**From:** Rachel . <blparishclerk@outlook.com>  
**Sent:** 25 July 2022 05:28  
**To:** Planning  
**Subject:** 3/2022/0667 - additional

Billington & Langho Parish Council have just read the submission from United Utilities regarding their denial that the culverted watercourse across the applicant's site is NOT one of their assets.

Proposed Site Plan

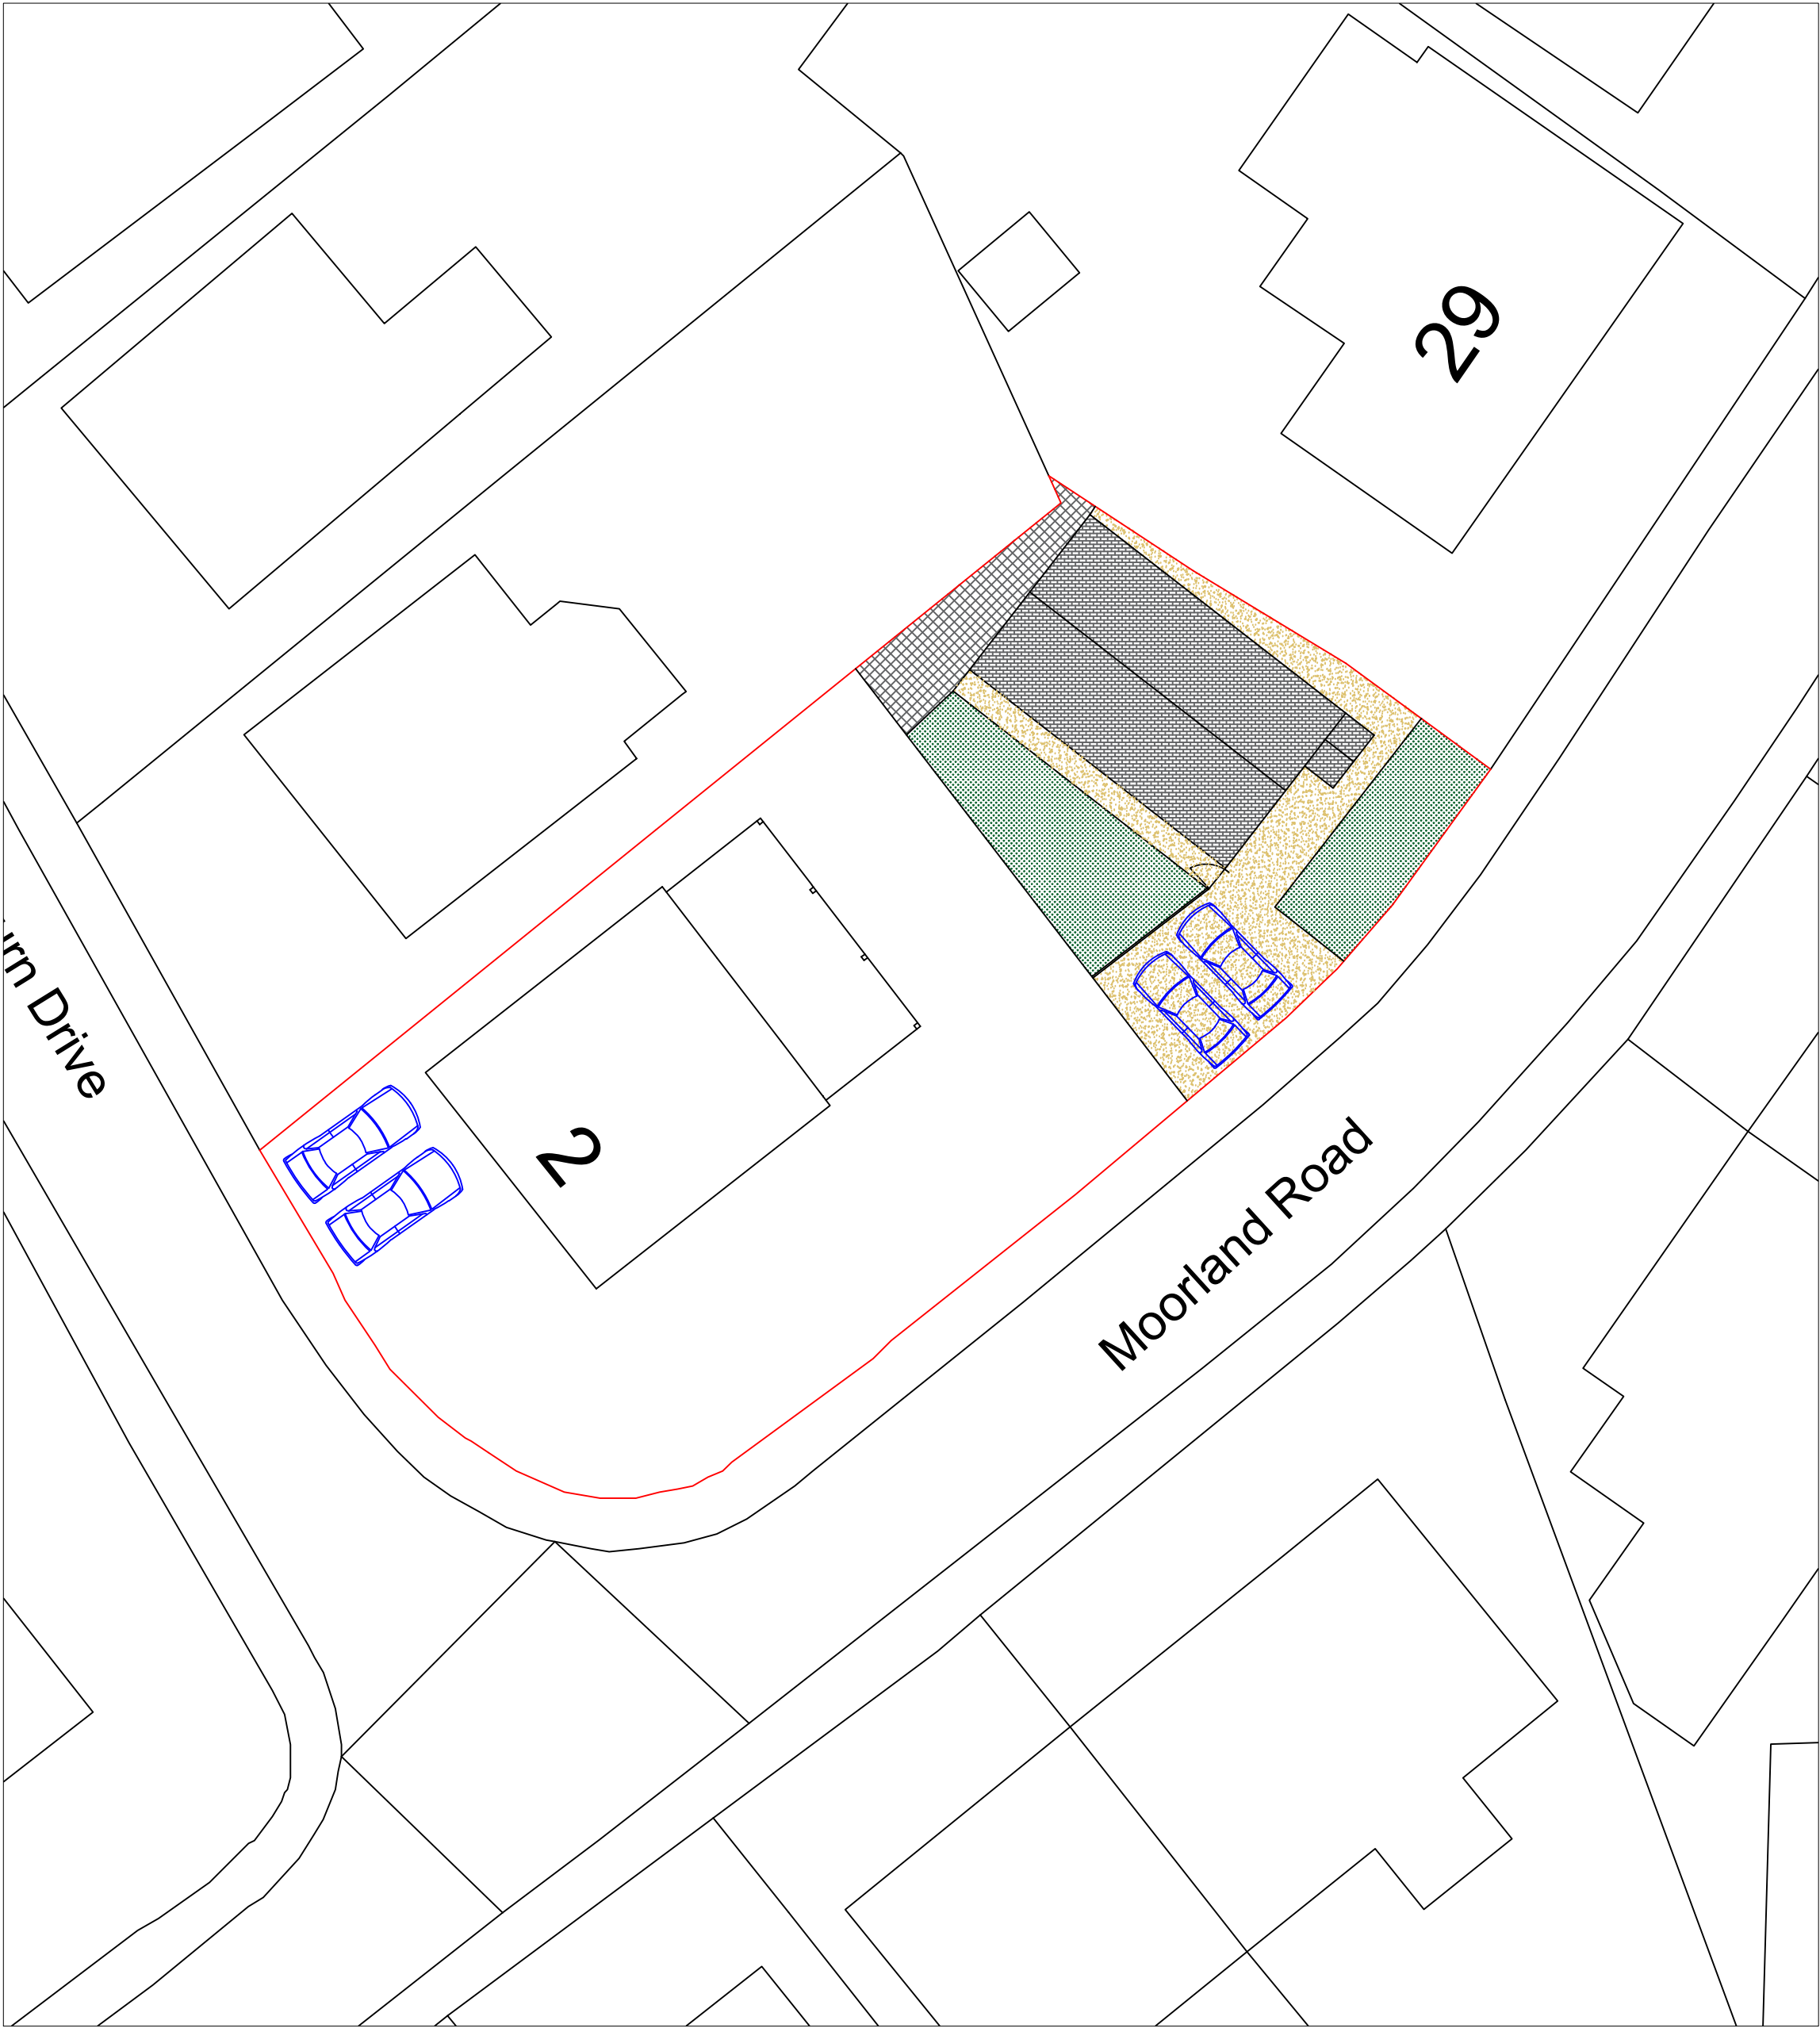
The Parish Council have now noticed that the applicant has not admitted to this underground watercourse across the proposed site on his application form, which is clearly incorrect.

The Council are aware of an underground watercourse that runs under the proposed site, under Langho Park, under the railway line and later becomes a visible small stream in a field further down the hill. It is possible that this was constructed at the time the railway was first built (circa 1850), but are unaware of the riparian owner.
